Subject: Environment Agency Response to: F/4/17/PL

Rife Cottage
1 Station Road
Ford
Arundel
West Sussex
BN18 0BJ

Our ref: HA/2017/119191/02-L01
Your ref: F/4/17/PL

Exisiting ancillary building to be used as a tourist unit. Resubmission of F/17/16/PL.

PROPOSED WORKS TO ALLOW EXISTING ANCILLARY BUILDING TO BE USED AS A TOURIST UNIT. RIFE COTTAGE, 1 STATION ROAD, FORD.

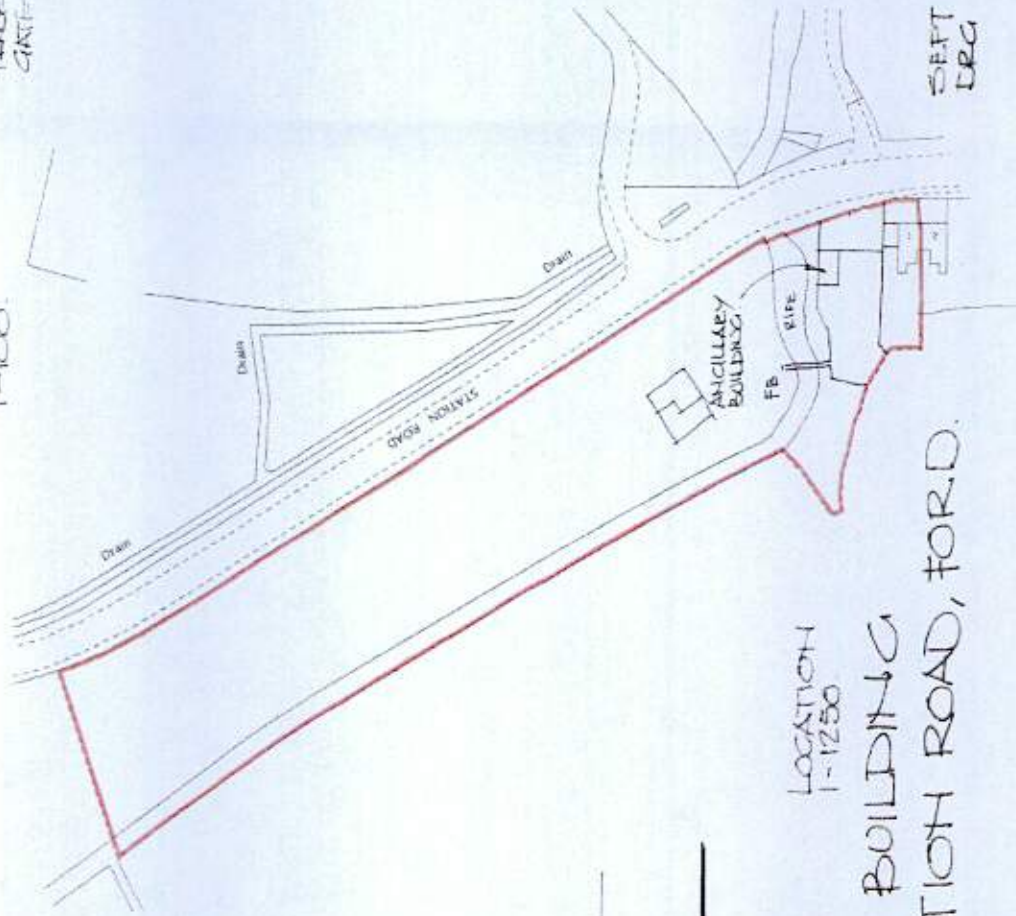
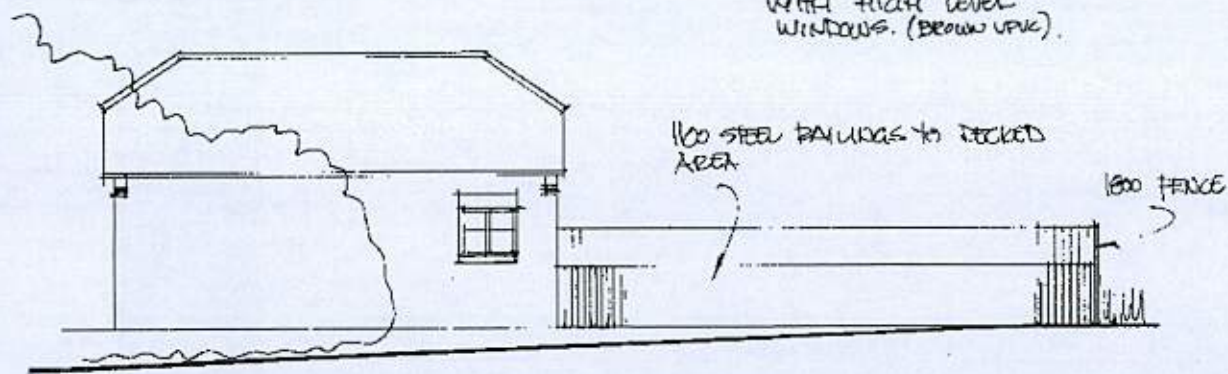
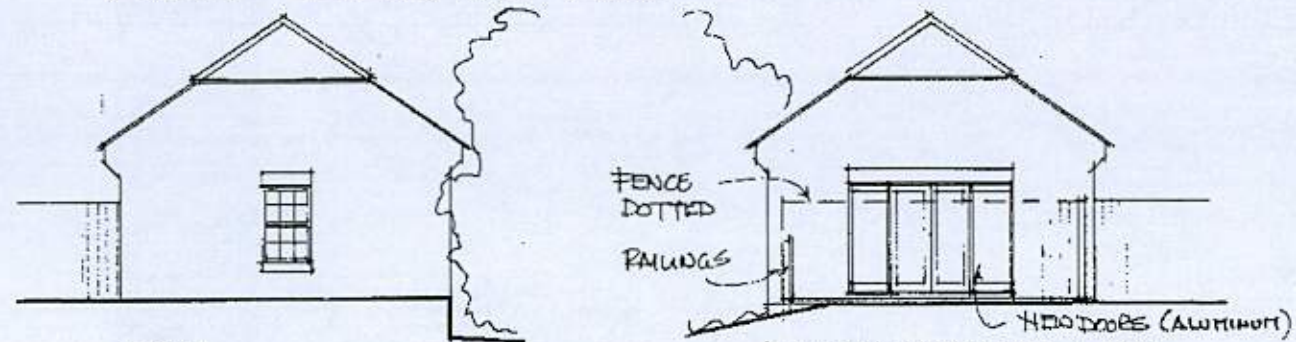
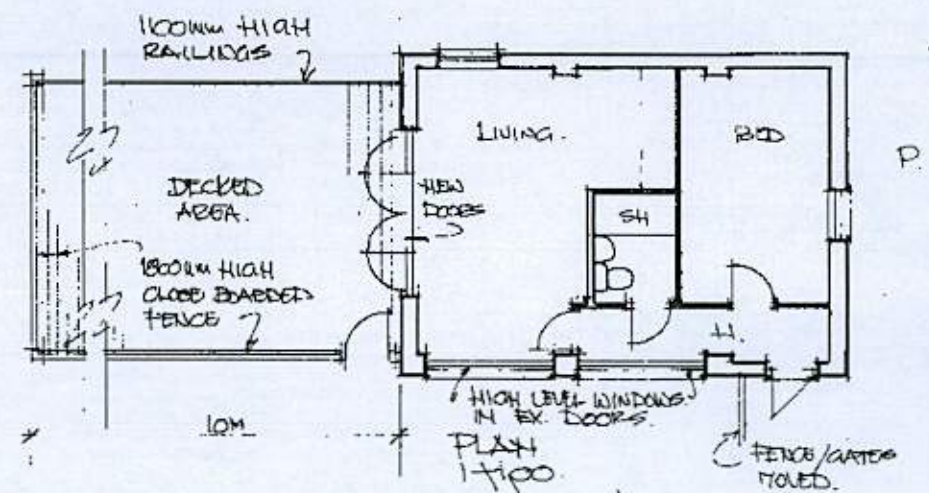
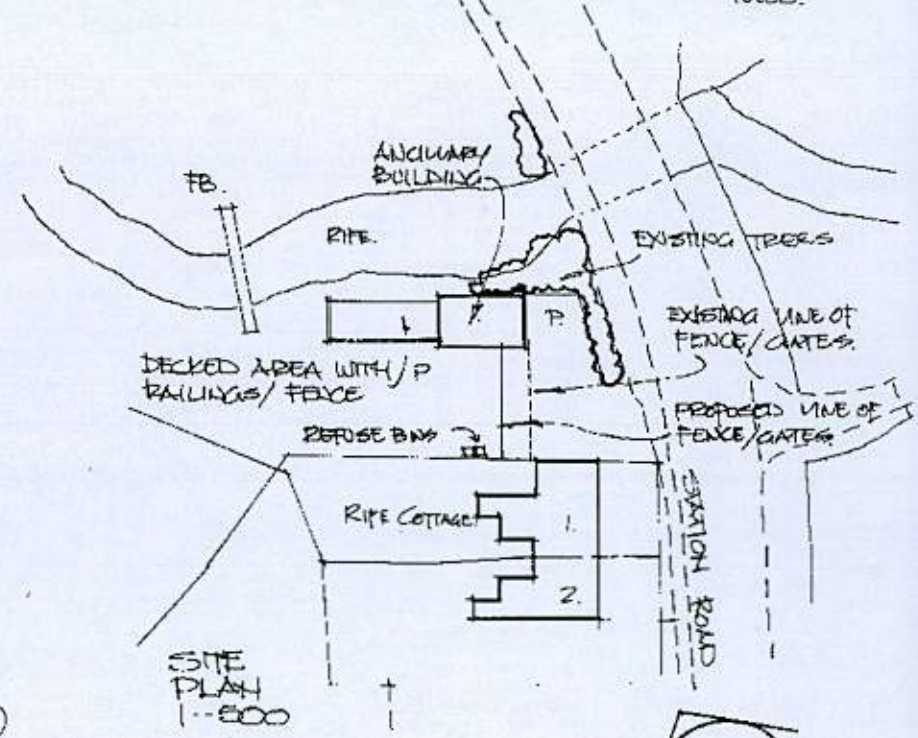
Whilst it is stated that the existing floor levels are to be raised 600mm, information has not been provided as to what the existing ground floor levels of the ancillary building are. The Product 4 information provided by the Environment Agency gives an undefended 1 in 200 tidal flood risk level of 4.04mAOD. For any potential occupants to be safeguarded from flooding, finished floor

levels will need to be above this level. Therefore the existing ground floor level needs to be provided so as a comparison can be made.

SEPT '16
DRG 2A

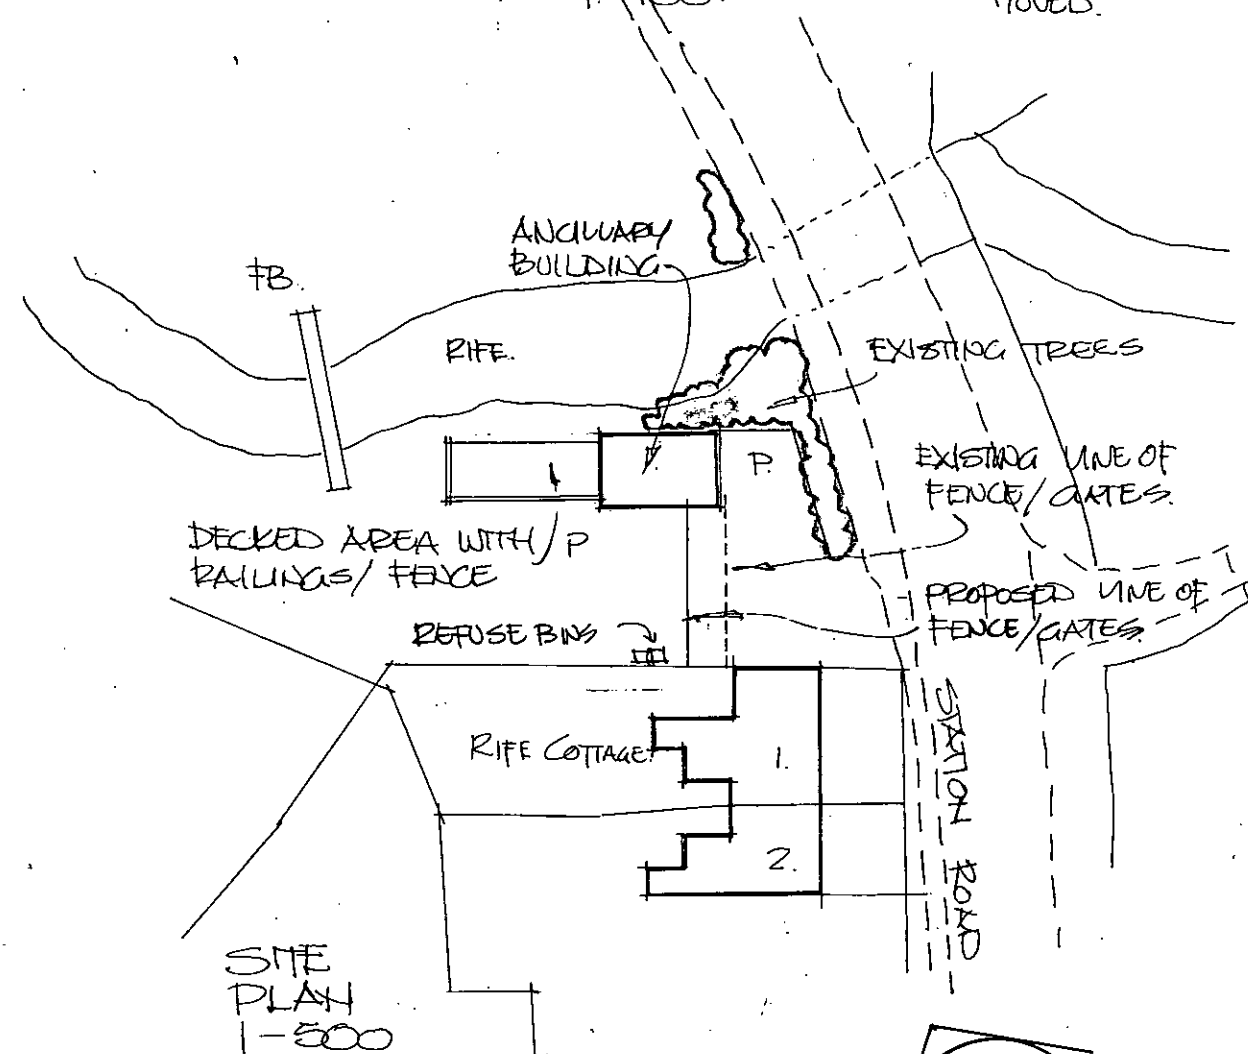
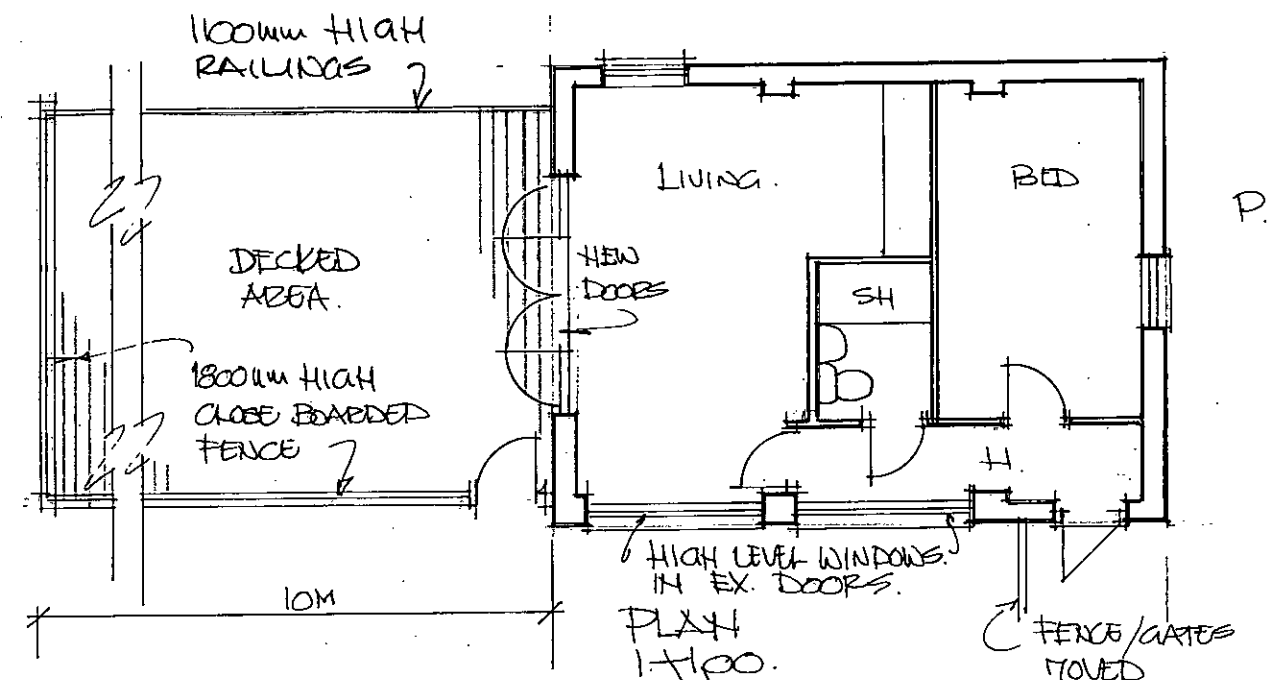
We would also not support a void under a building, as a means of flood flow conveyance, in a severe flood scenario, due to the risk of blockages which could form.
